Application number 2019/62/94075/W

Location: 4, Olney Street, Slaithwaite, Huddersfield, HD7 5EG

Description / Development: Erection of pair of semi-detached dwellings

5 February 2020

Front elevation (1:100)

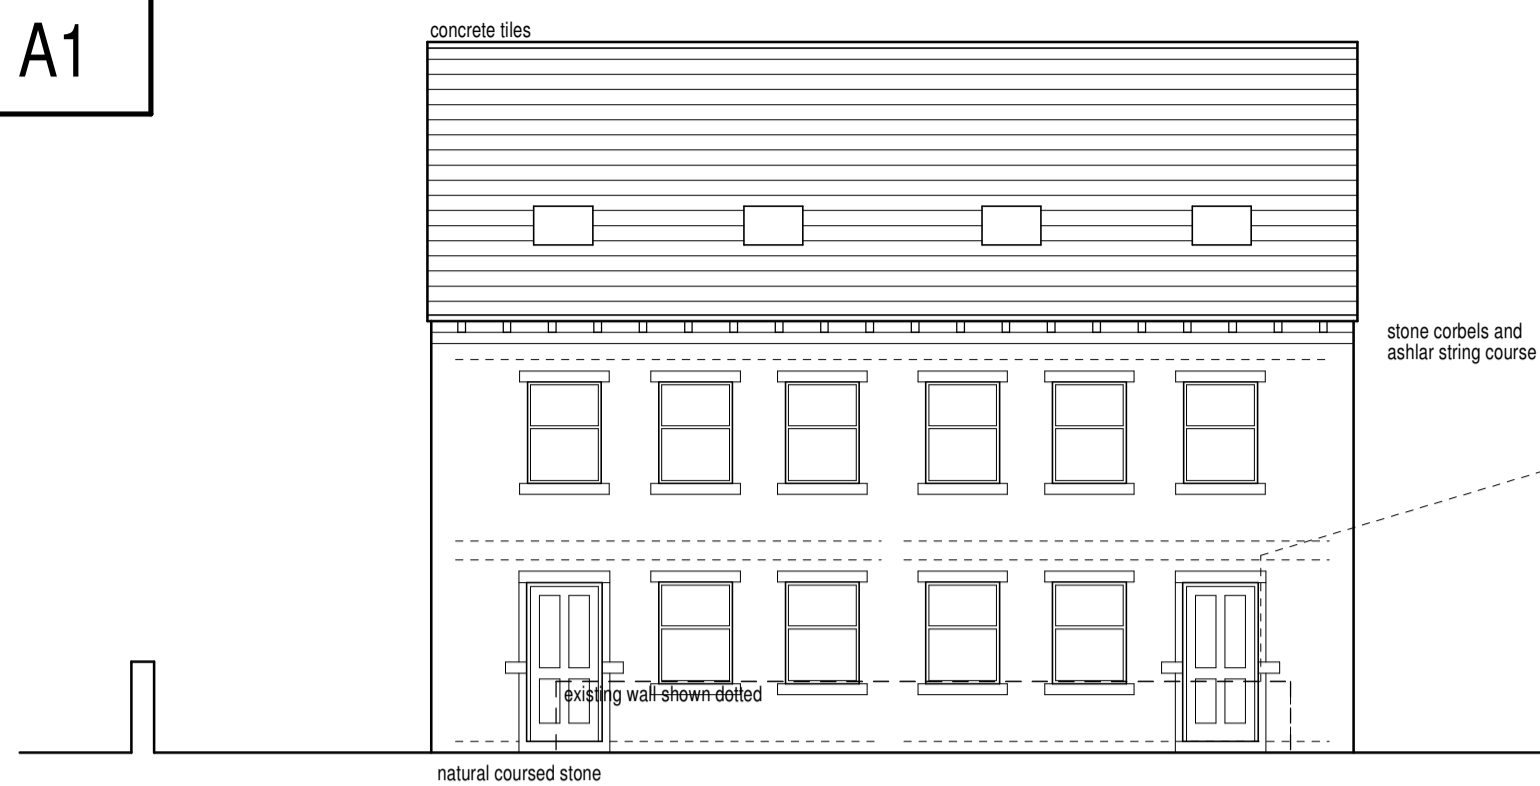
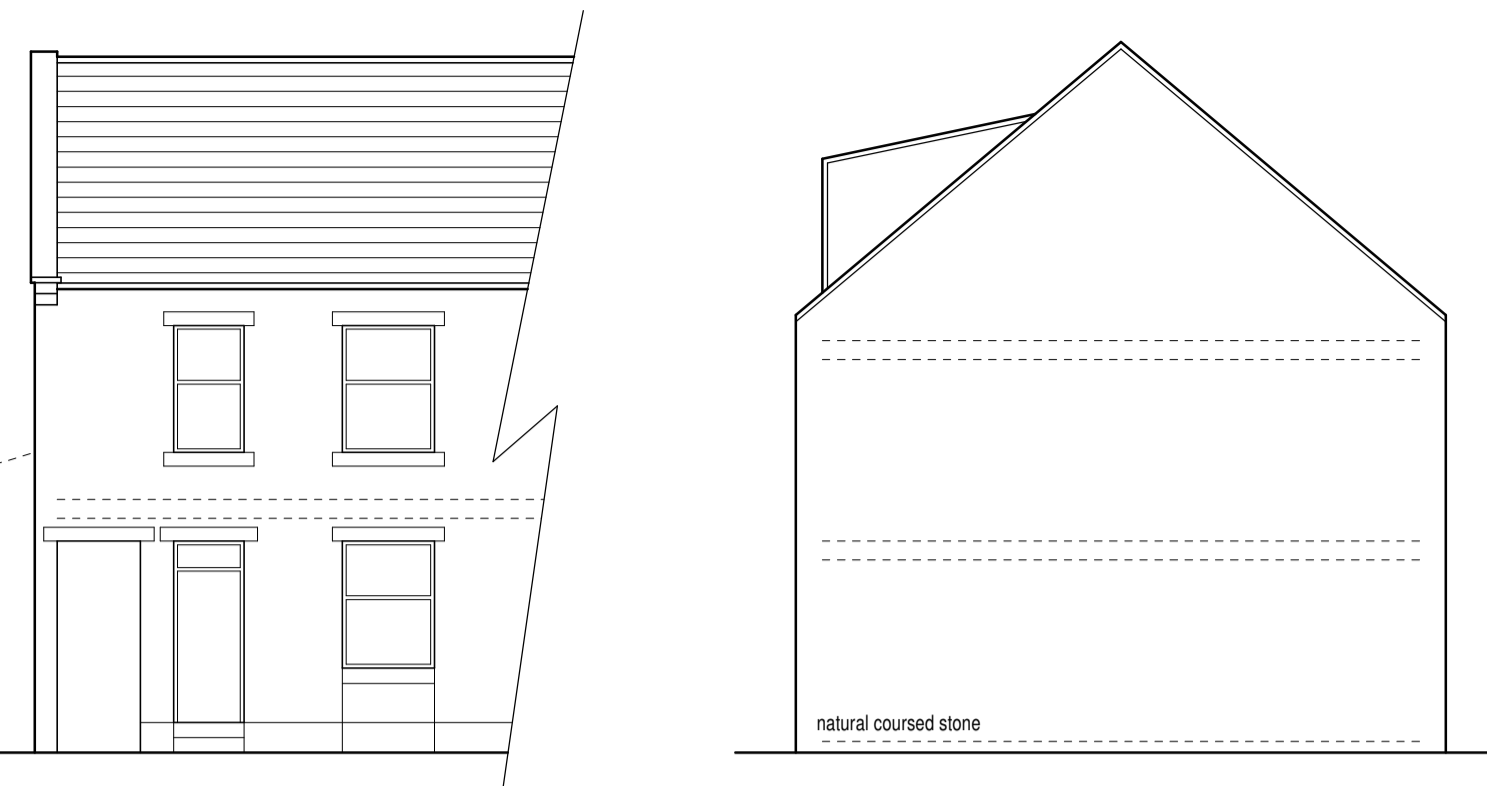
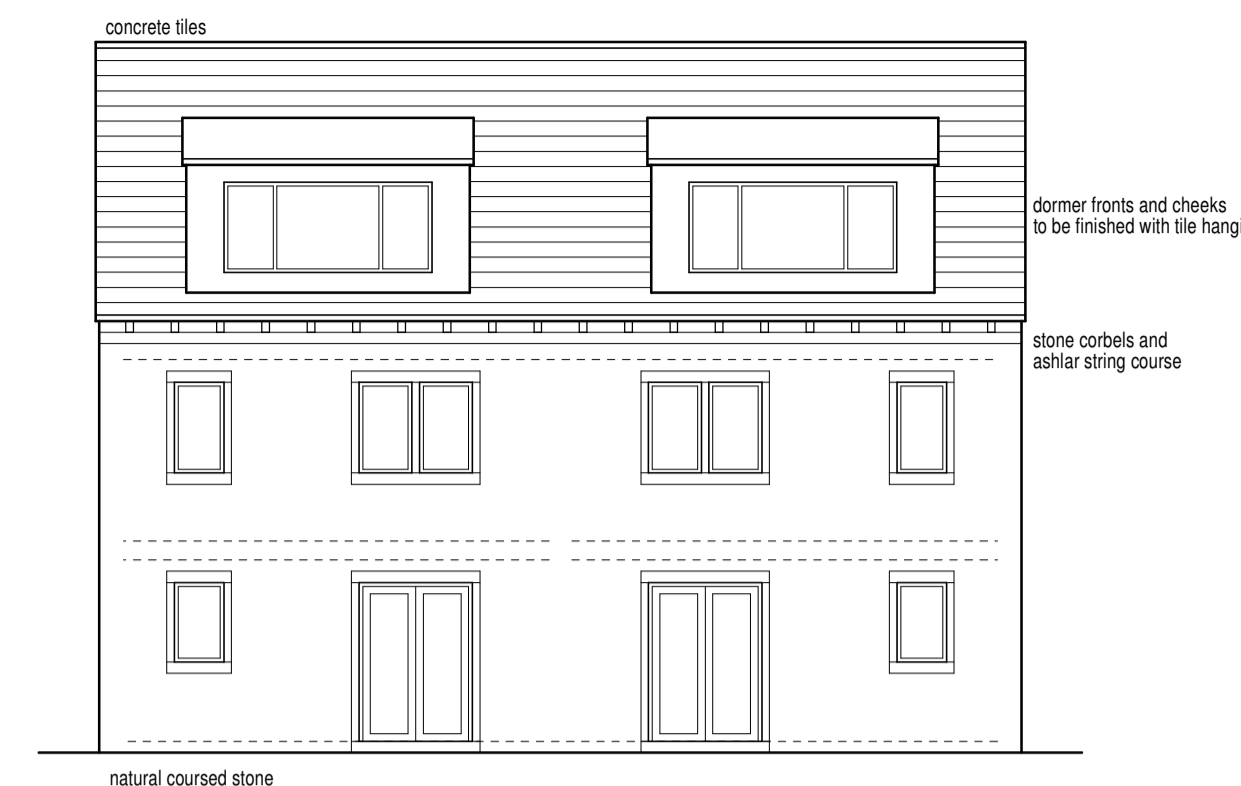
The front elevation drawing shows the wall façade around the door frame to be made from ashlar stone jambs. This arrangement is unique to any buildings in the area and bears no resemblance to the vernacular architecture of any building in the vicinity. All surrounding buildings that the proposed development is trying to match have split faced coursed stone reveals to the door openings, so the proposed building should continue this style.

The roof covering shown on the plans is concrete tiles. The design of the dwellings is trying to match the appearance and style of adjacent buildings, which are Welsh blue slates. The minimum requirement for the roof should be at least using a Welsh blue artificial slate to match the surroundings.

Rear elevation (1:100)

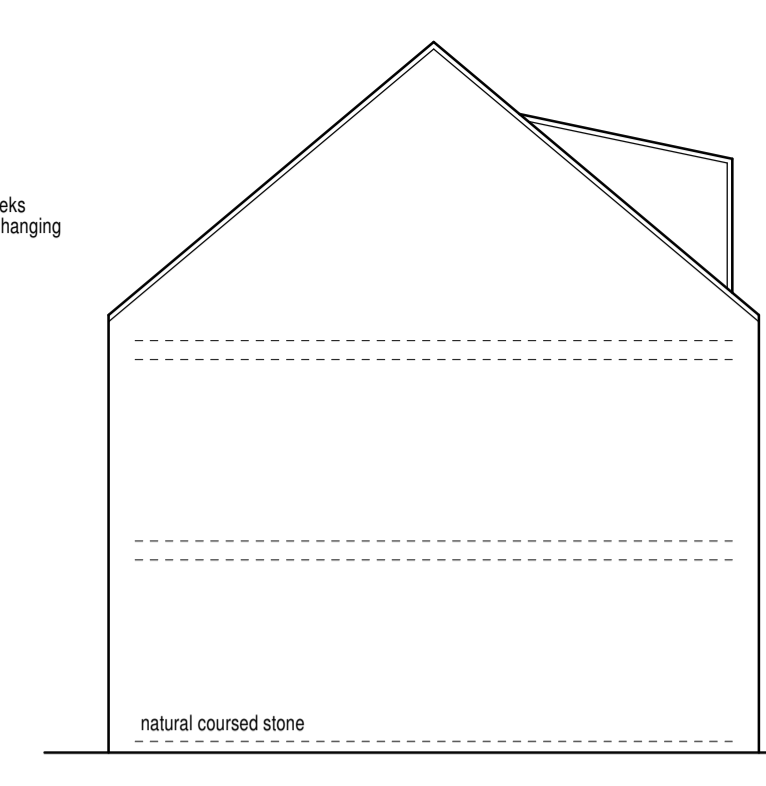
The inclusion of a dormer window to the rear elevation roof, would again stand out like a sore thumb. There are two similar dormer windows in the area and both look atrocious. The remaining vast majority of buildings in the area that have roof lights use Velux style windows, which do not detract from the original building design. The proposed development has Velux style windows on the front elevation and should continue this style to the rear.

Again the rear elevation drawing shows the wall façade around the door frame and window frames to be made from ashlar stone jambs and mullions. This style matches nothing in the area. The rear design should change to continue the style of the front elevation windows with split faced coursed stone reveals.

Proposed site plan 1:200.

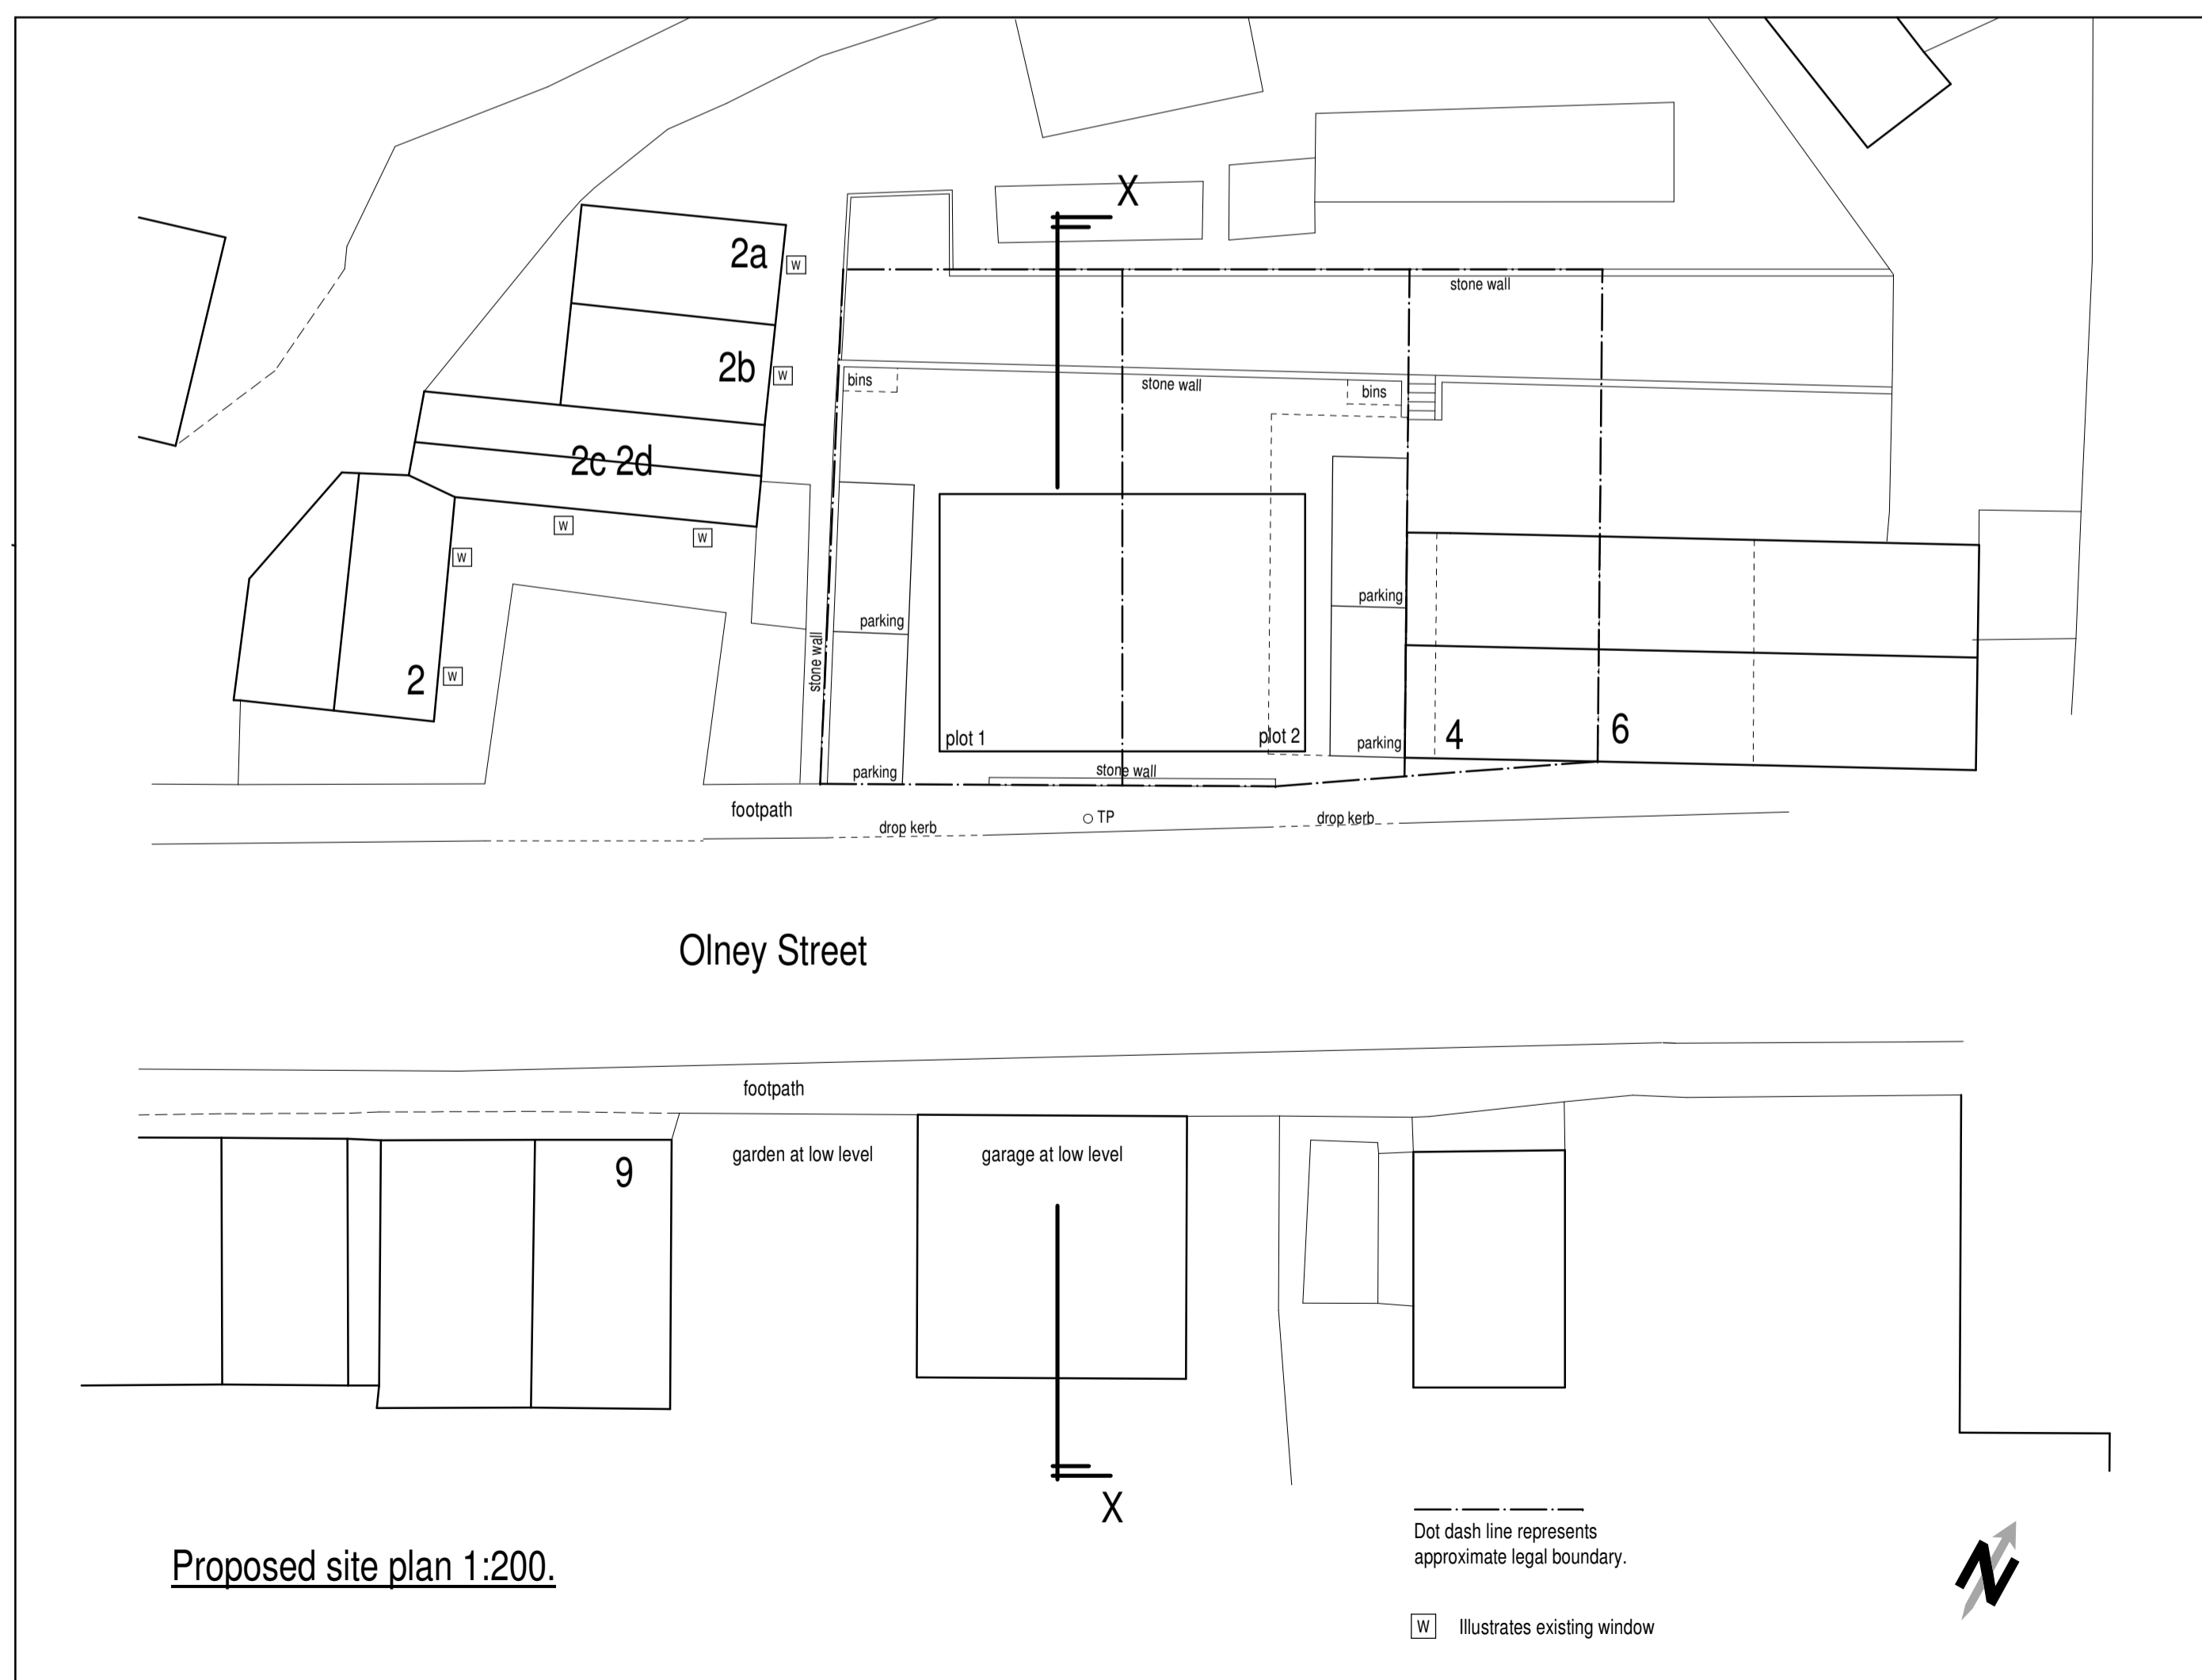
The proposed development removes the two off road garage parking spaces used by no 4 Olney Street and these spaces given over to the new development to allow it to meet the parking requirements for new builds. Where will the cars of no 4 now be parked? On the road side or two wheels on the pavement as is now becoming the norm. If this development is allowed to be built, a condition must be to have the developer install bollards at the problem drop kerb areas between no 2 and no 10 Olney Street to stop vehicles driving on and parking on the pavements.

The second part of pedestrian safety is that when the garage at no 4 was constructed, a low stone approx. 1.2x1.2m wall was pulled down between the passage/garage and between the end of the house/rear of the pavement. This small wall should be reinstated to give pedestrians using the passage adjacent to no 4 protection and time to see vehicles parking or setting off in the two adjacent parking spaces.

Outline section (1:100)

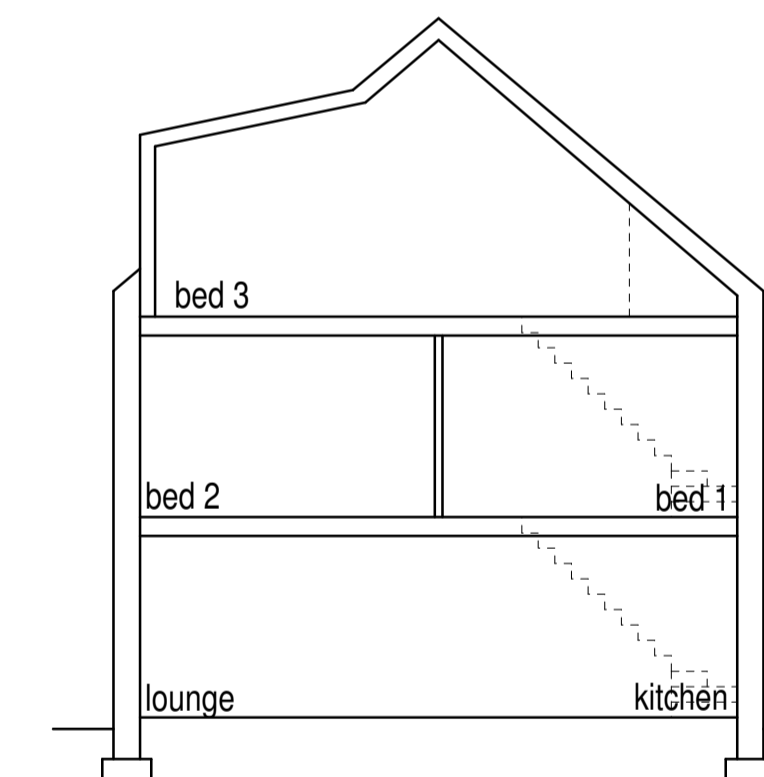
The foundations on the drawings shown traditional strip footings around 600mm deep. However, the site is an old quarry with an additional 2.5m of general fill from another nearby building site and the adjacent property has a 2.5m basement, so the foundation design will have to change.
